Subject: FW: CM/46/20/HH

Letter of no objection.

I have just learnt about the above numbered planning application and I am writing to inform you the Location Plan and Block Plan are both incorrect.

BLOCK PLAN 1/500

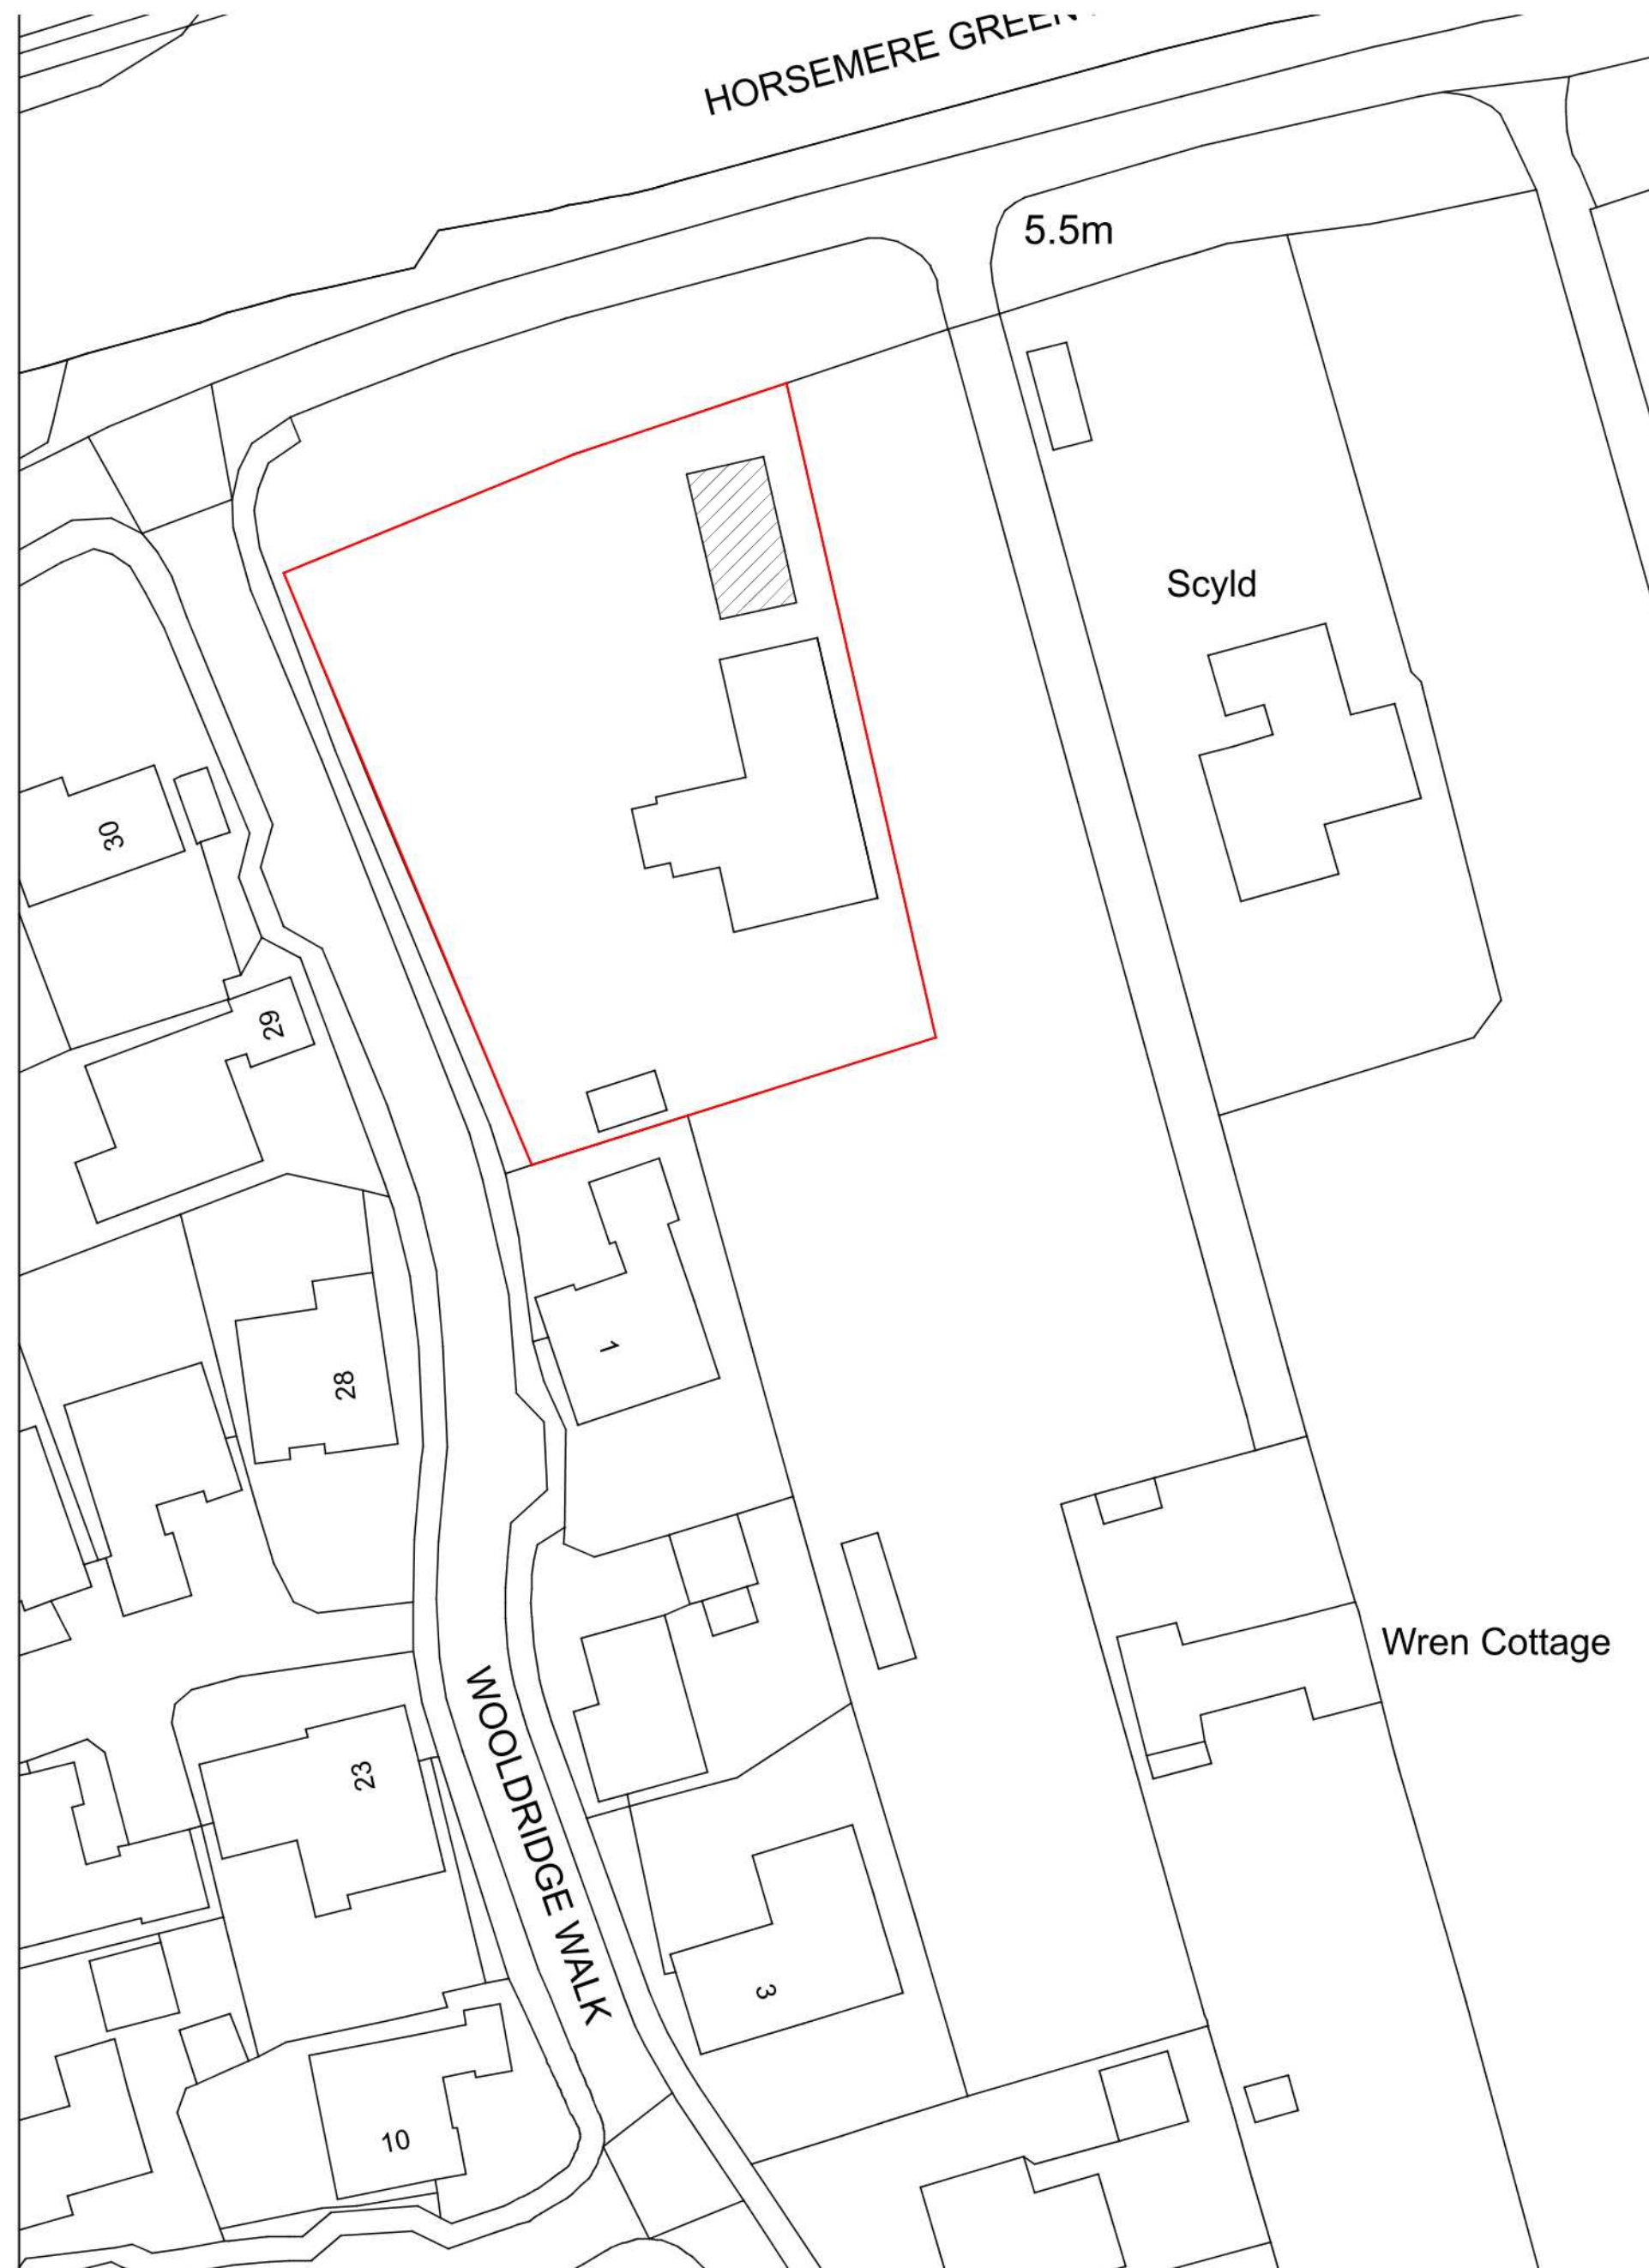
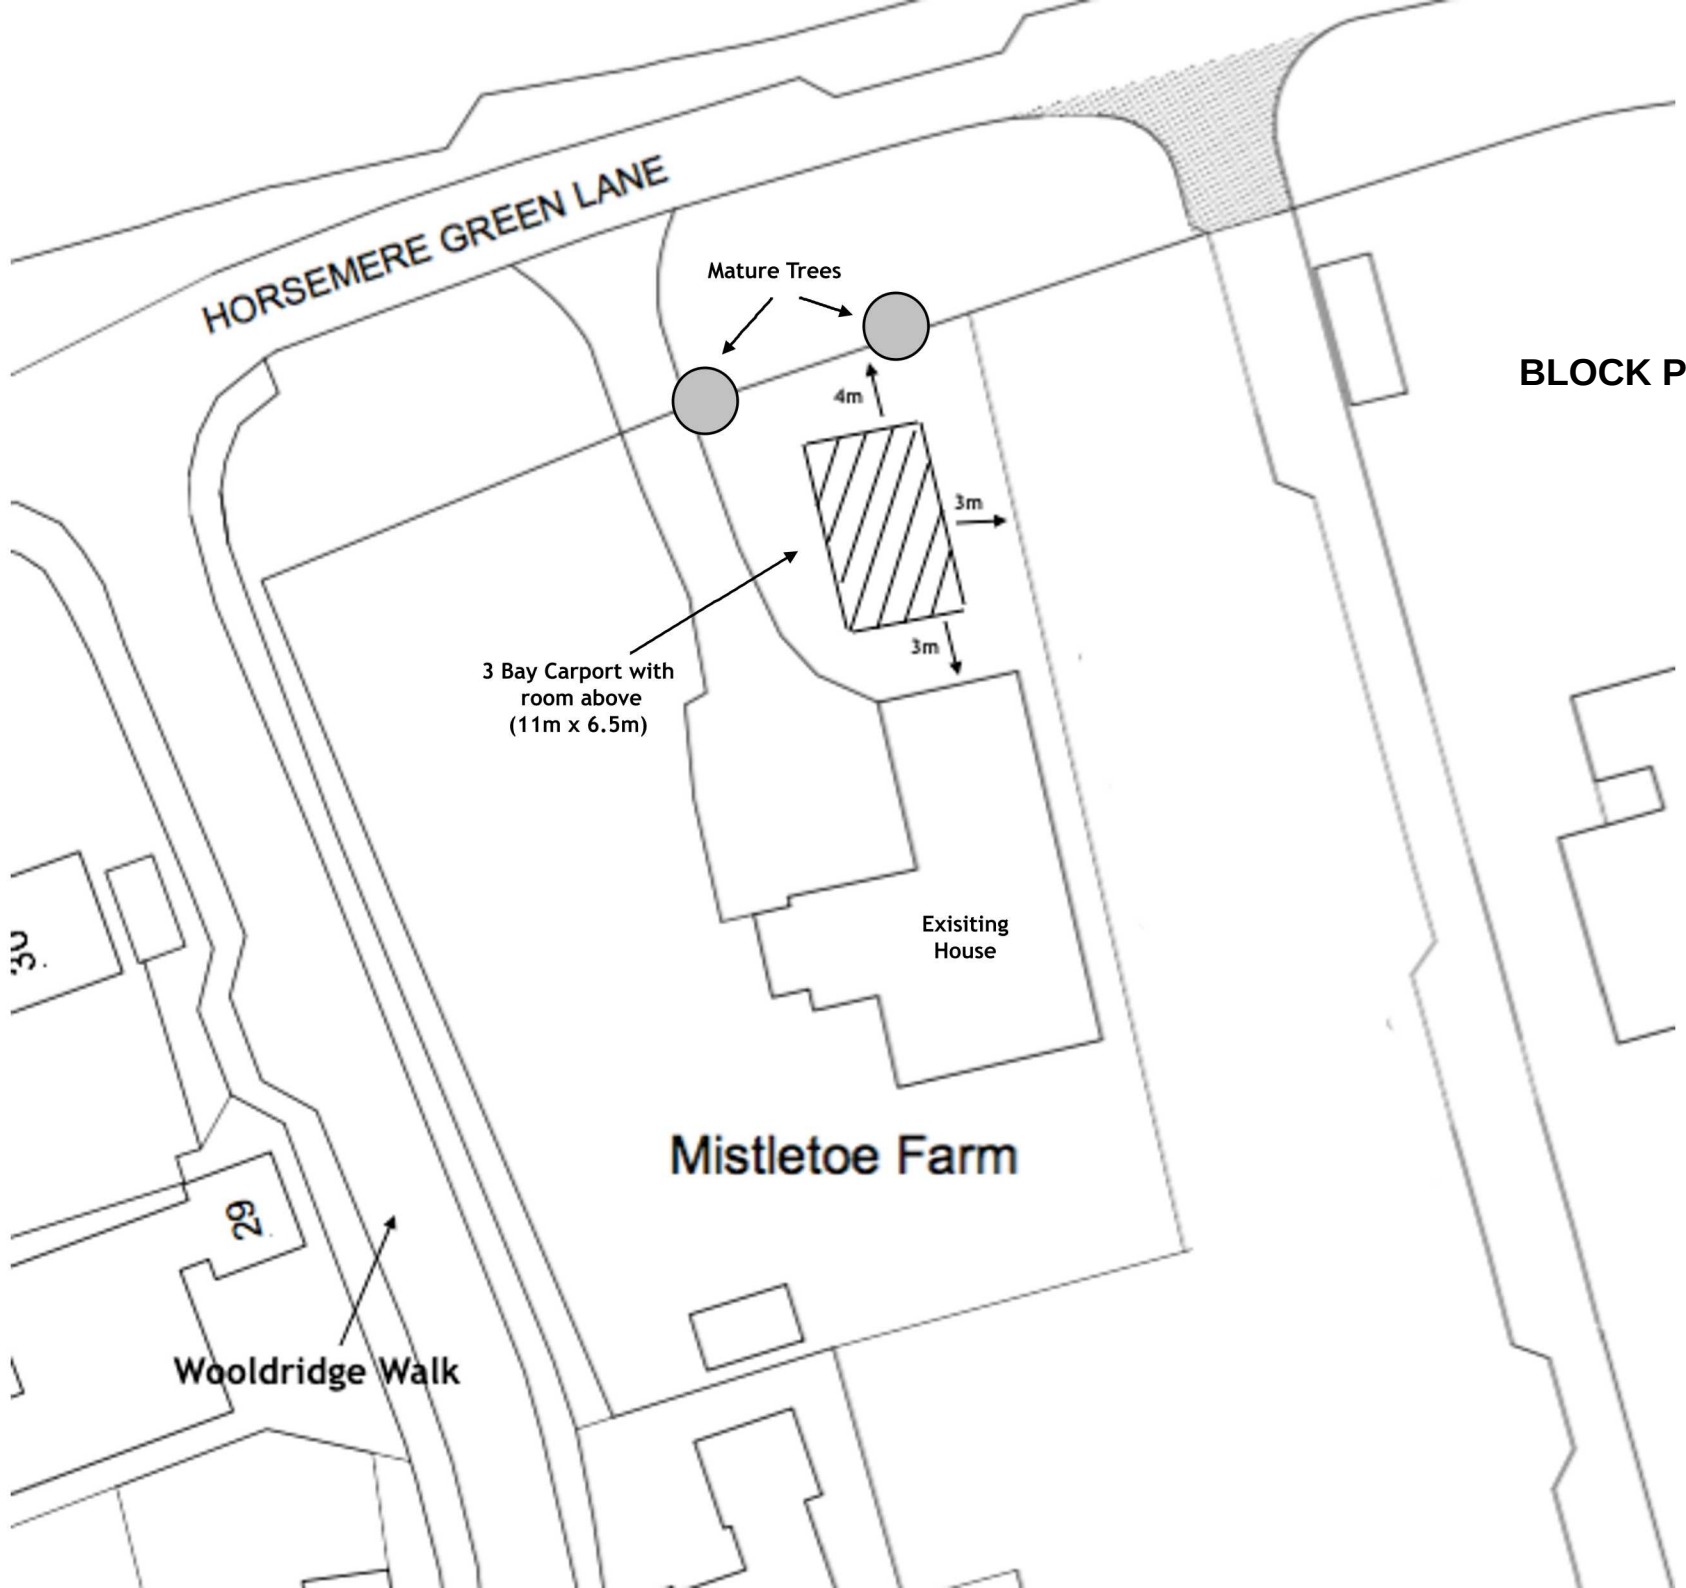
The red line needs to be amended to show it going North from the 1 Wooldridge Walk fence line up to the front boundary.

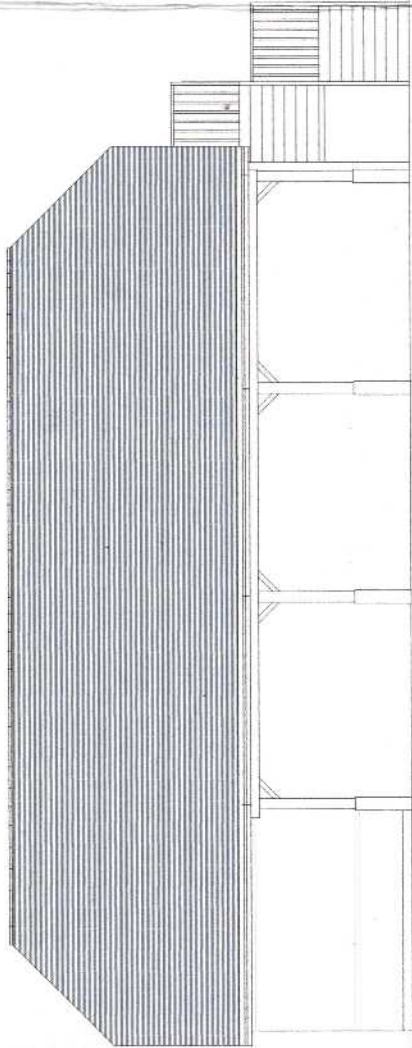
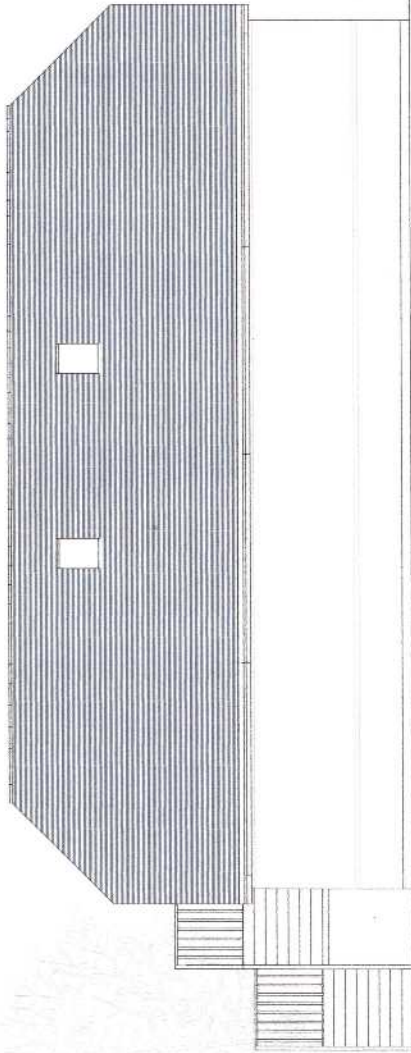
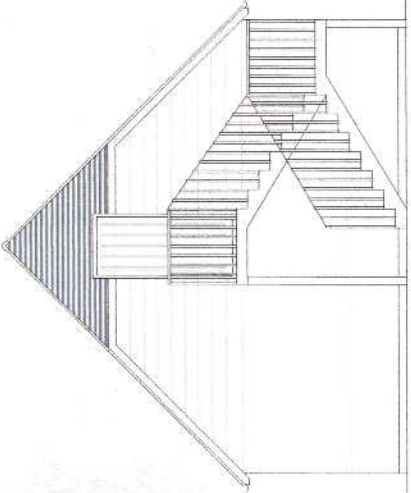
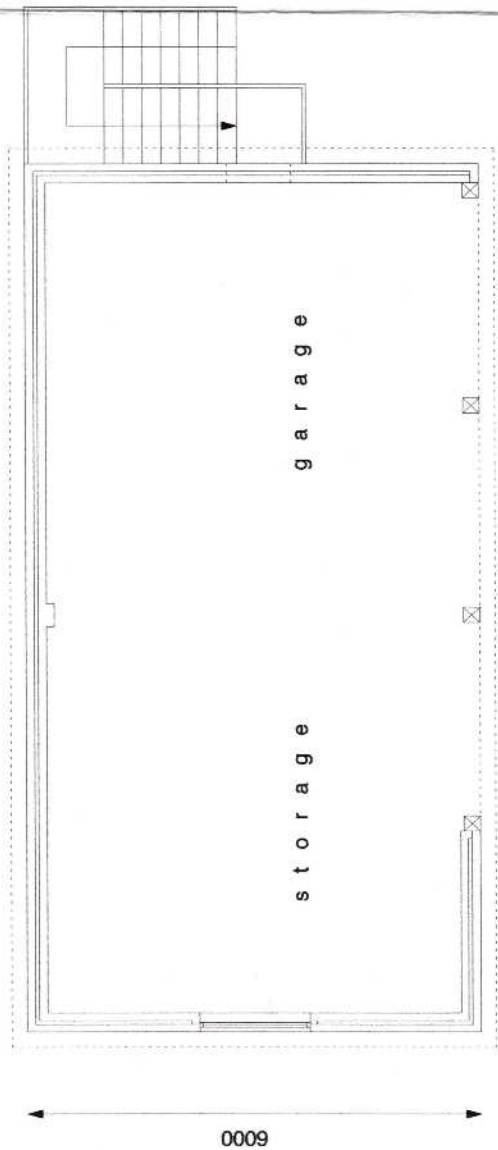
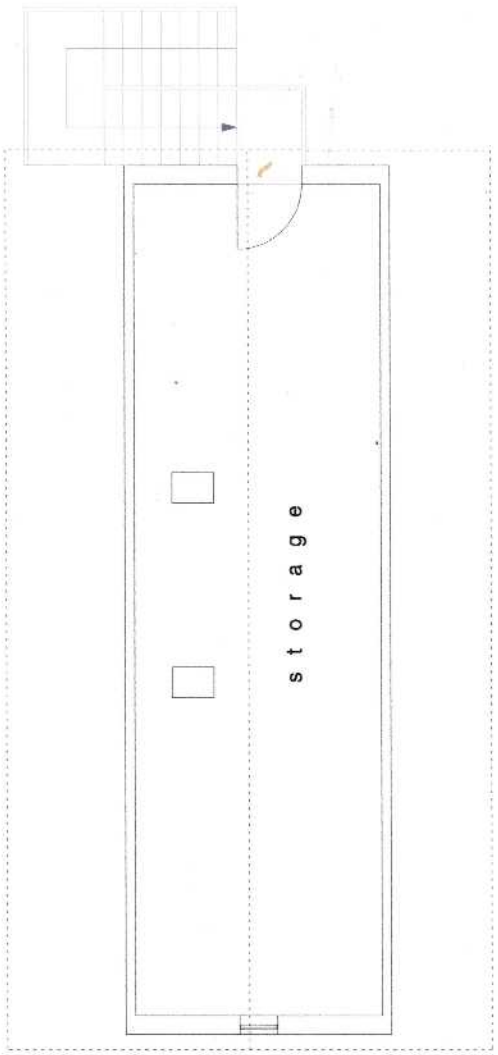
With regard to the triple garage, storage area and dwelling- we don't have any objections per se but feel an internal staircase would be preferable as the outside steps and landing would overlook adjacent gardens/land but will leave that with you and your planning department.
